# STAFF RECOMMENDATION

PROJECT INFORMATION										
<b>Project Title</b>	Dell's Nursery Rezone			<b>Date of Report</b>	September 19, 2023					
<b>File Number</b>	PA 22041			<b>Attachments</b>	See Section 3.0 for links to Exhibits					
<b>Administrative Recommendation</b>	Approve the preliminary Commercial Site Plan and Concurrent Rezone from Medium Density, Single-family (R-4.5) to General Commercial (GC) in order to construct two single story office/warehouse buildings totaling approximately 30,600 SF.									
BACKGROUND SUMMARY										
<b>Applicant</b>	104 <sup>th</sup> Street LLC									
<b>Request</b>	The applicant is requesting Site Plan Approval and Concurrent Rezone from Medium Density, Single-family (R-4.5) to General Commercial (GC) in order to construct two single story office/warehouse buildings totaling approximately 30,600 SF.									
<b>SEPA Status</b>	A SEPA Mitigated Determination of Non-Significance was issued on July 21, 2023. The appeal period expired August 4, 2023; no appeals were filed.

Sheet L-3

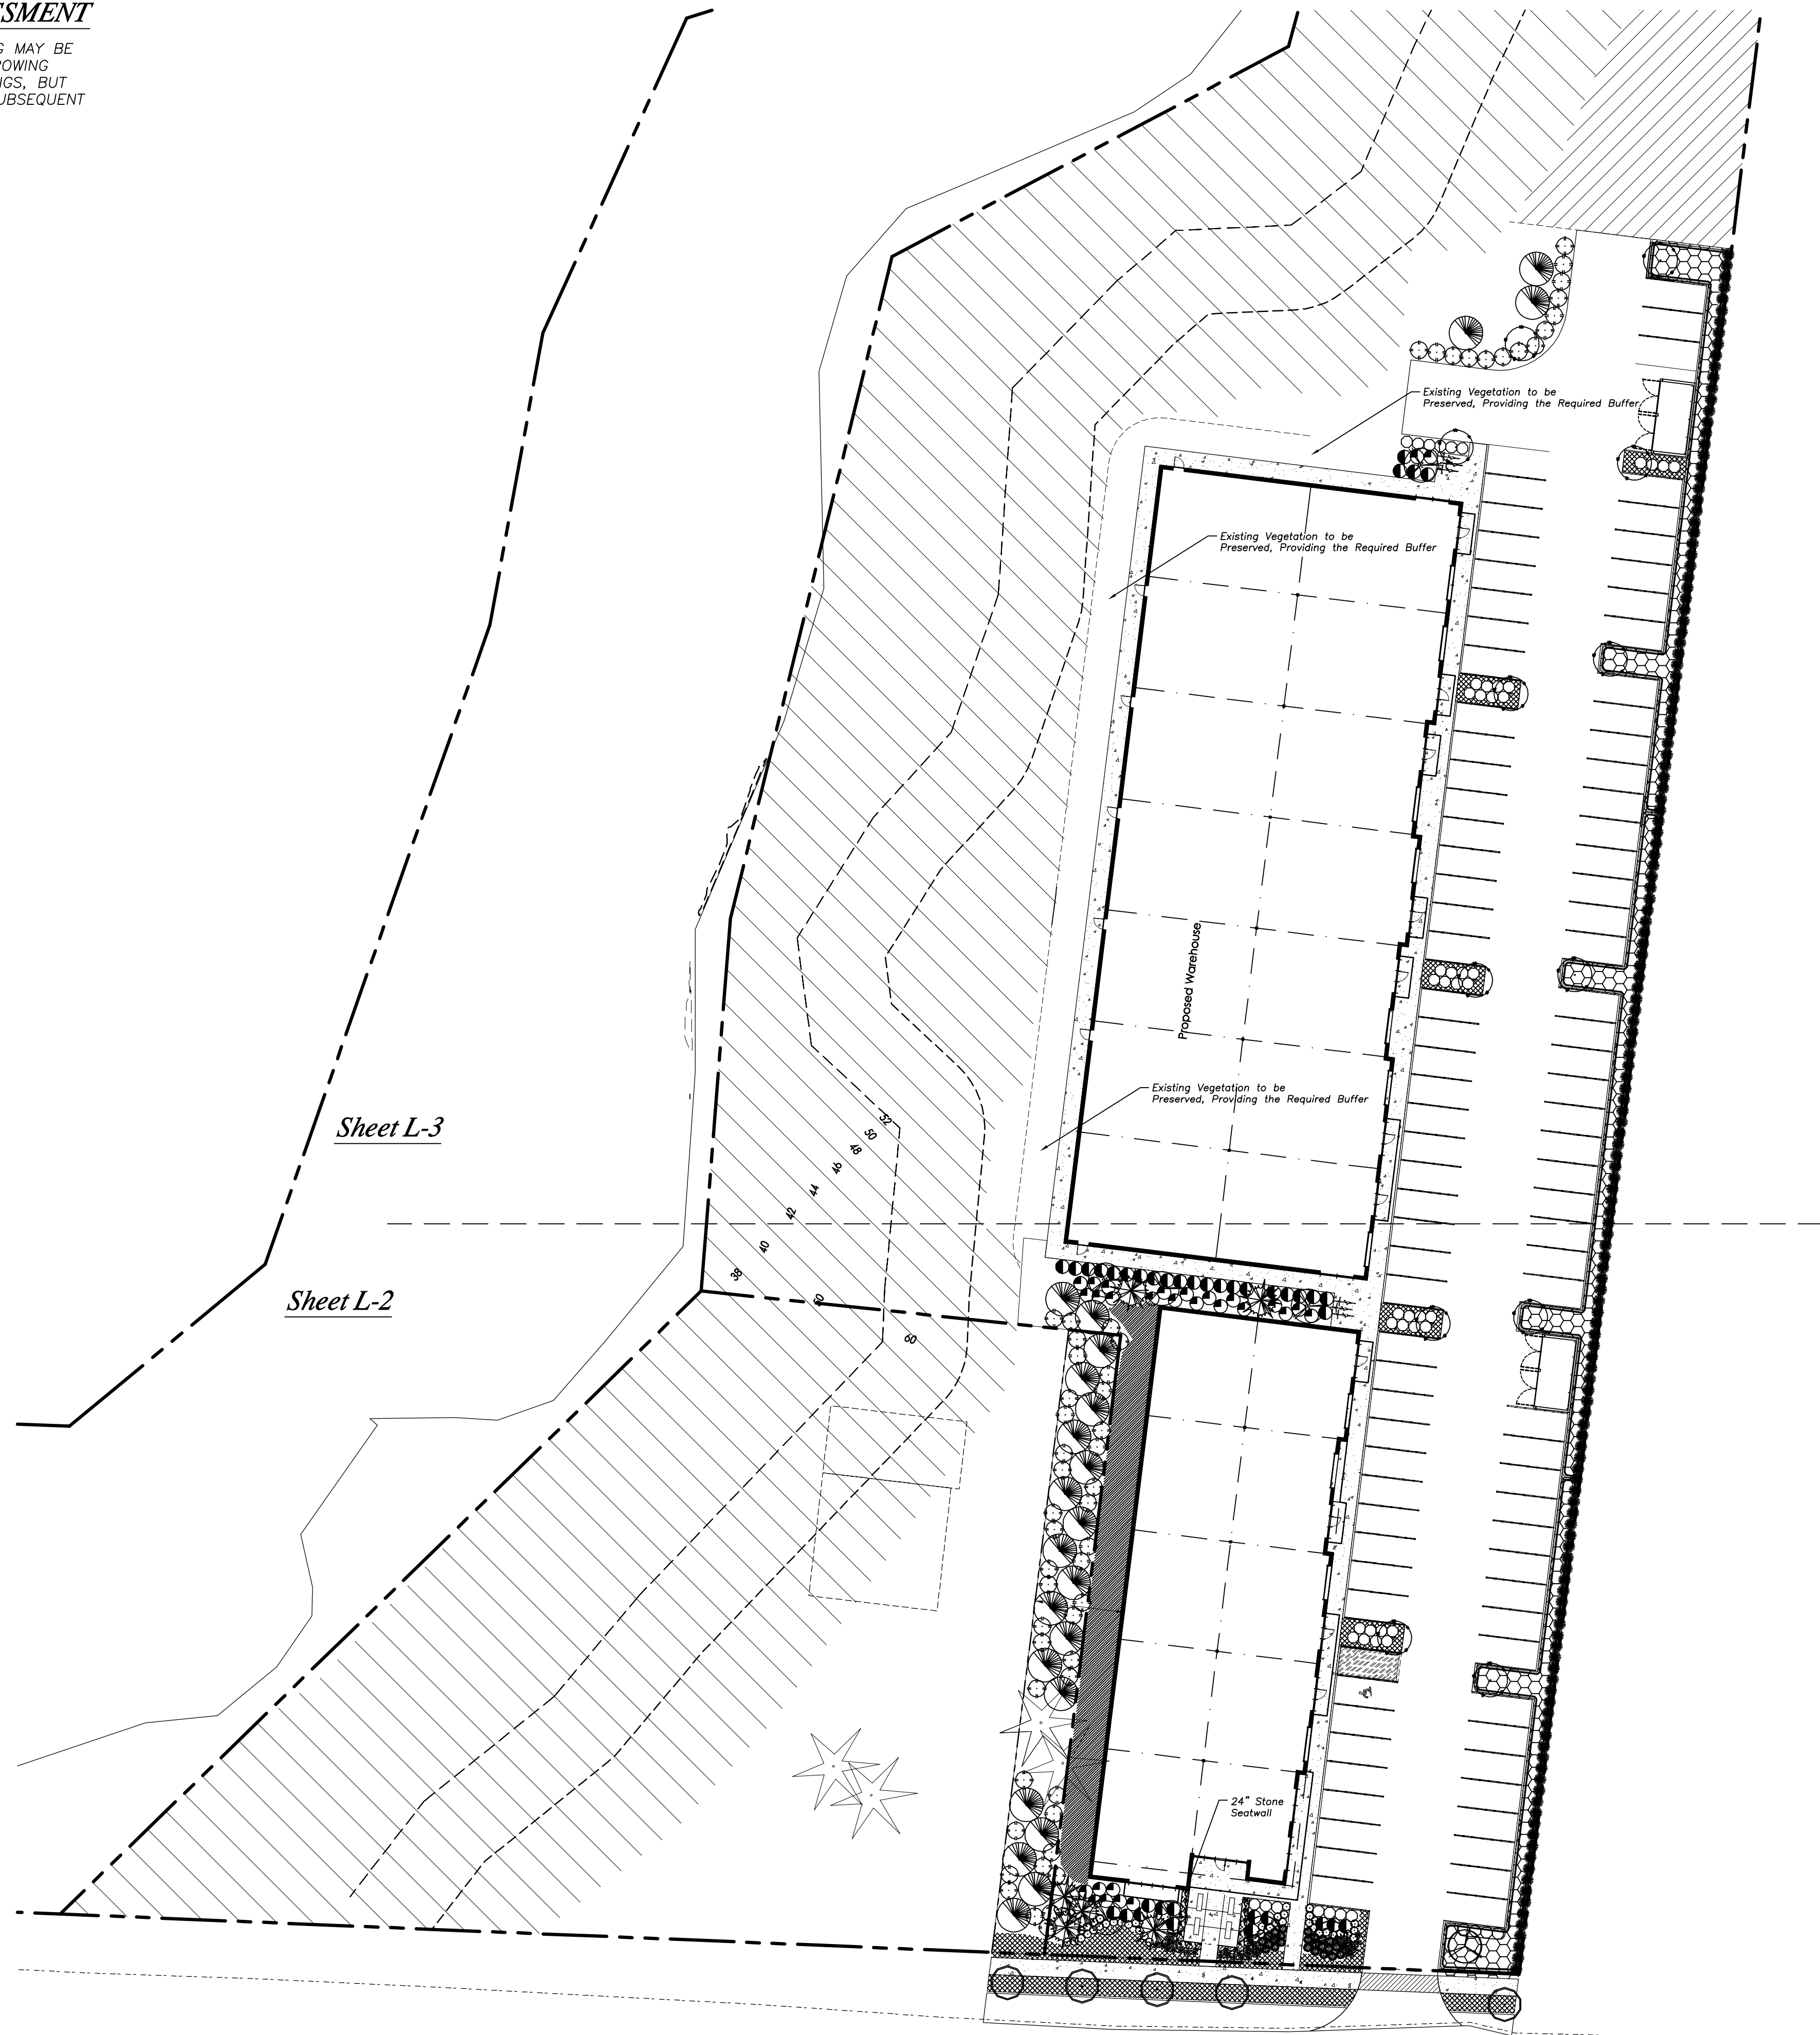
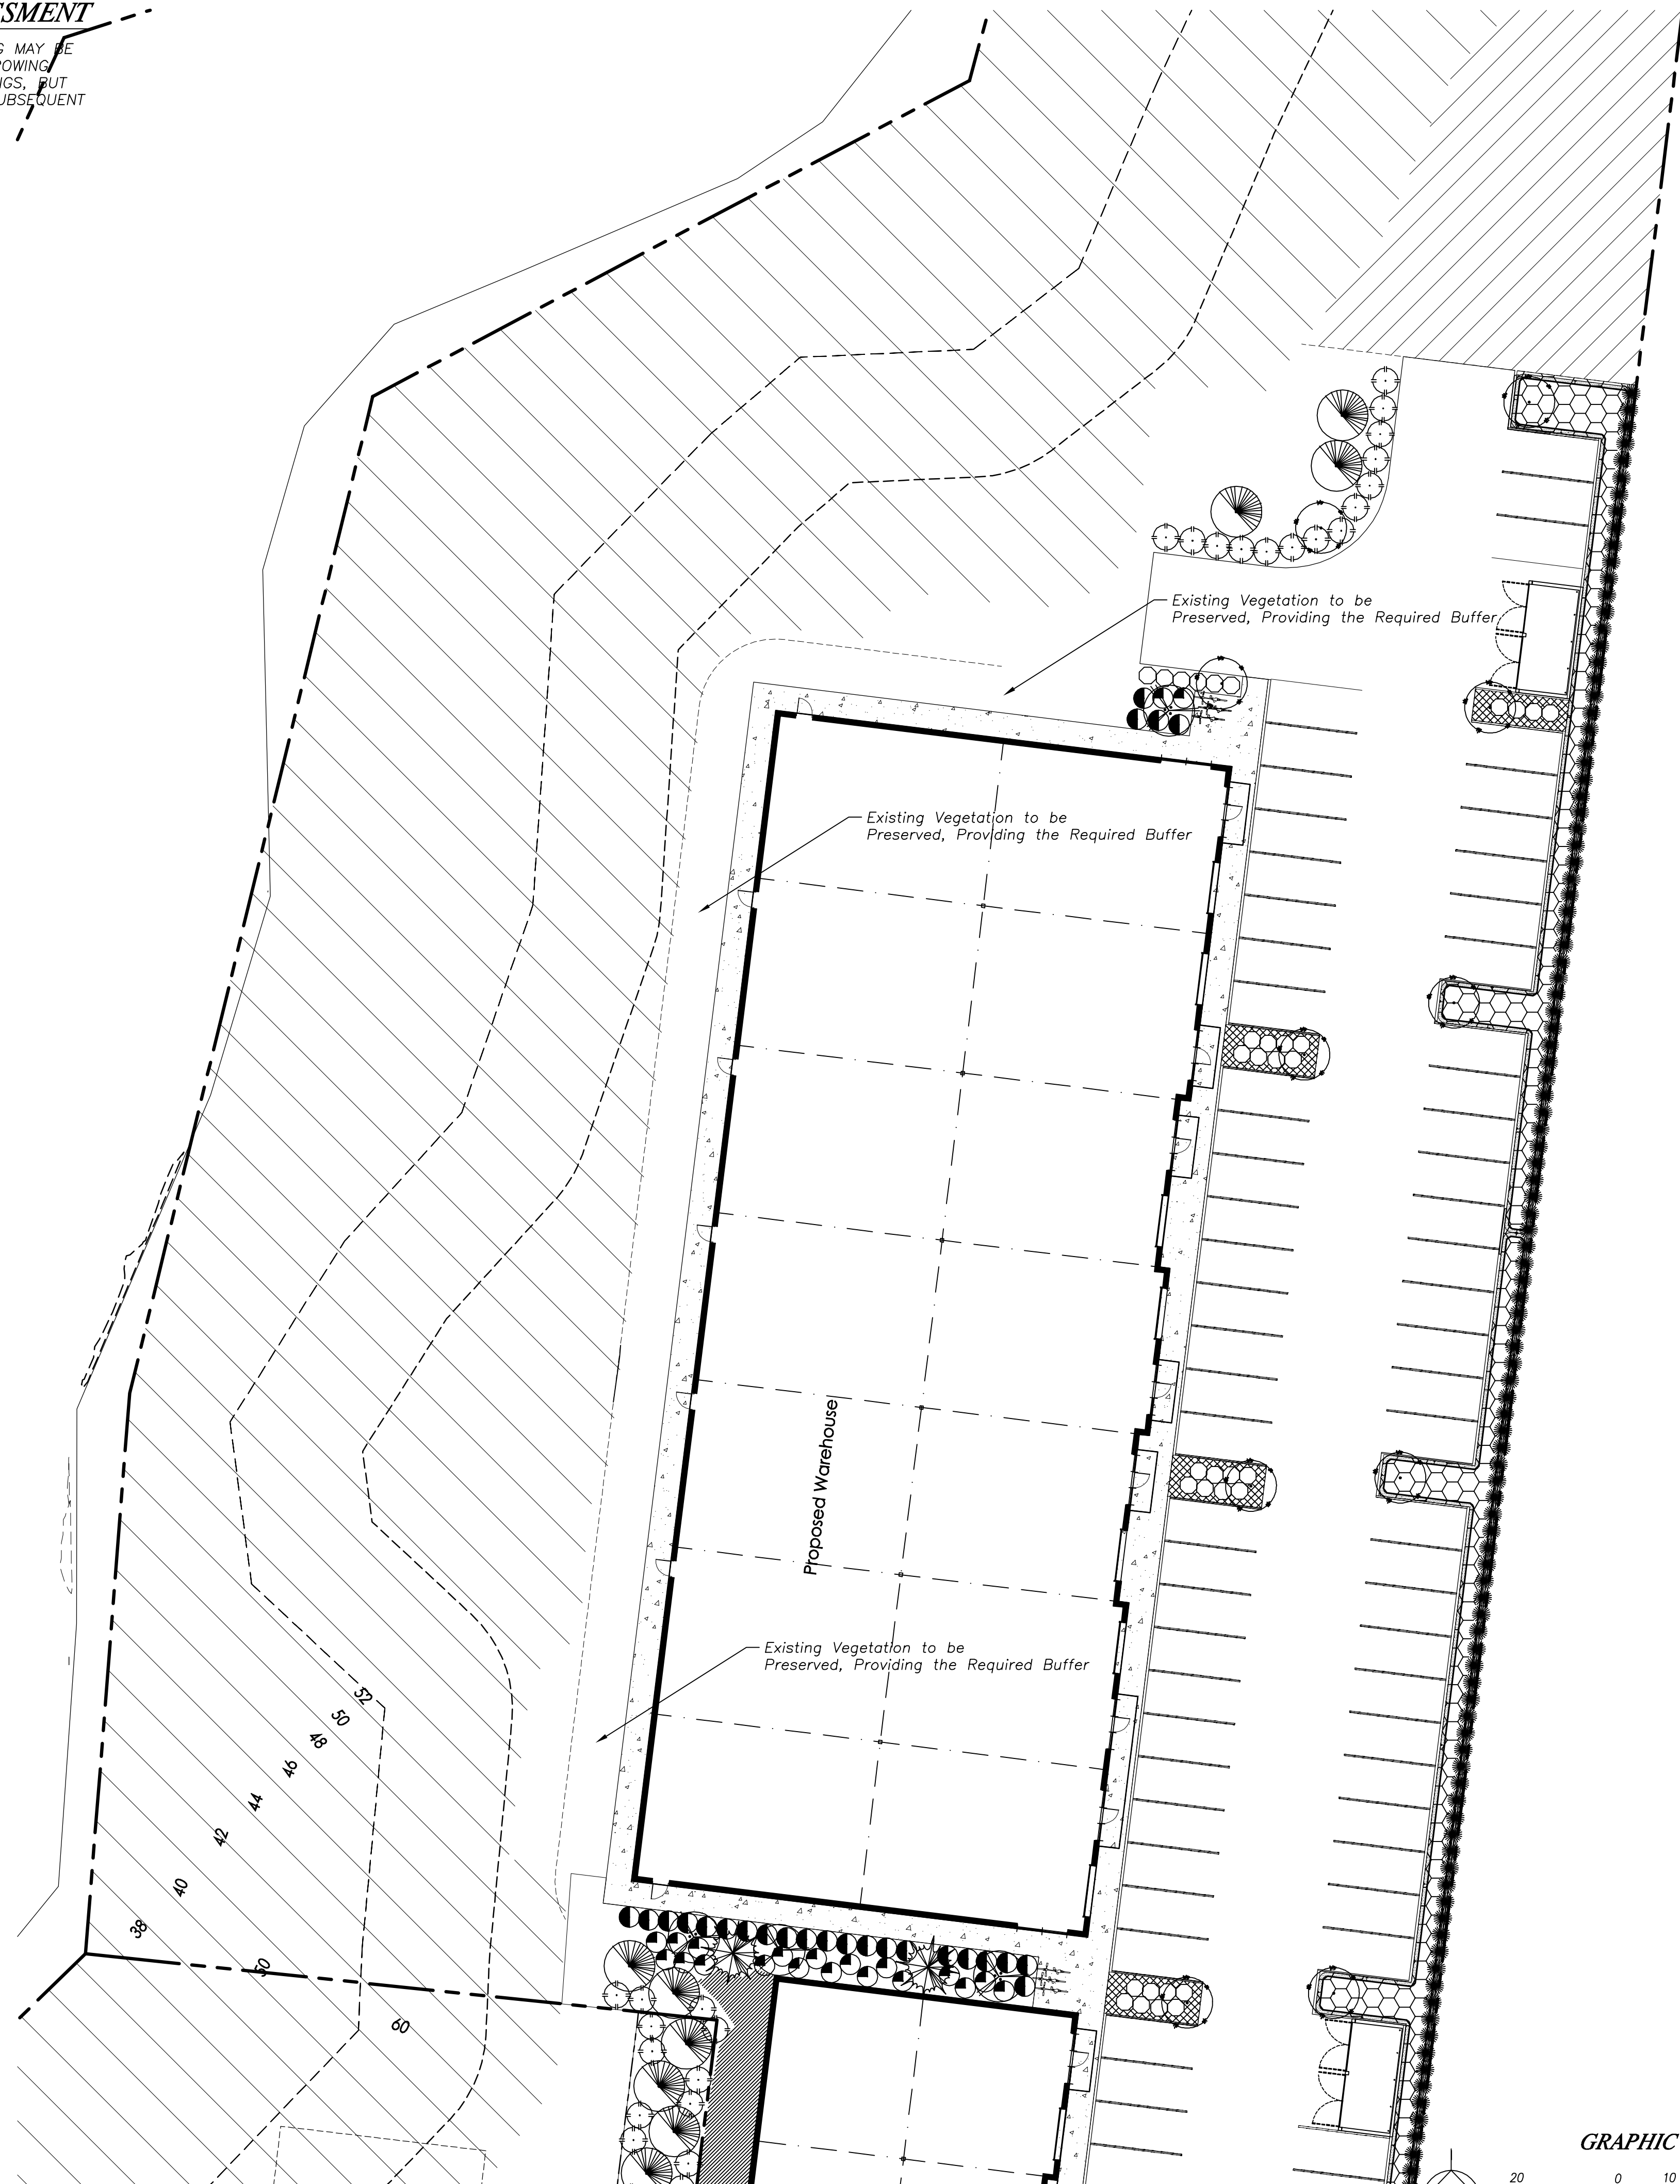
Summary of Comments: On the landscape plan, the applicant does not seem to include their plans for the 'wetland buffer addition'. A clear plan outlining how this area will be restored and monitored is needed.

Applicant's Response: Detailed Mitigation plans with details plantings will be submitted with the Civil Construction Plans.

Staff Response: Prior to any construction activity the applicant shall be required to submit a FINAL Critical Areas Mitigation Plan, developed in accordance with [MMC Chapter 22E.010 Critical Areas Management](#), and approved by the Community Development Department.
